From: Cleaver, Elizabeth [REDACTED]
Sent: 29 January 2014 14:56
To: Cian Cronin
Subject: Y/99/13/ Land to the north and east of St Mary's Church, Yapton

TR110 (November 2011)An Executive Agency of
The Department for Transport**Developments Affecting Trunk Roads and Special Roads
Highways Agency Response to an Application for Planning Permission**

Referring to the notification of a planning application dated 8 January 2014, your reference Y/99/13/, in connection with the A27, at Land to the North & East of St Marys Church, Yapton, for 10.5 hectares of residential development (comprising up to 250 dwellings together with ancillary open space and landscaping), 14.9 hectares of public open space development to be laid out as public parkland and landscaped green corridors, vehicular access from Ford Lane, notice is hereby given under the Town and Country Planning (Development Management Procedure) (England) Order 2010 that the Secretary of State for Transport:-

Thank you for consulting the Highways Agency on this application for 10.5 hectares of residential development (comprising up to 250 dwellings), 14.9 hectares of public open space development with vehicular access from Ford Lan

Road Safety Study Area

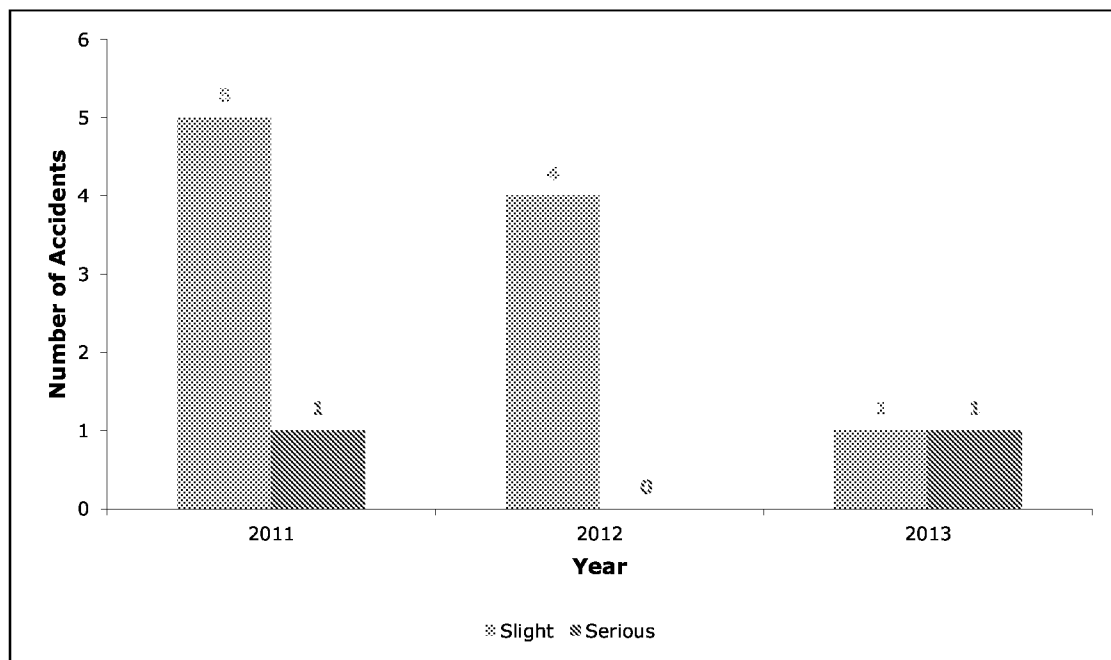
No accident data has been provided for the A27 with Yapton Lane junction. Please could you ask the applicant to provide accident data for the last five years?
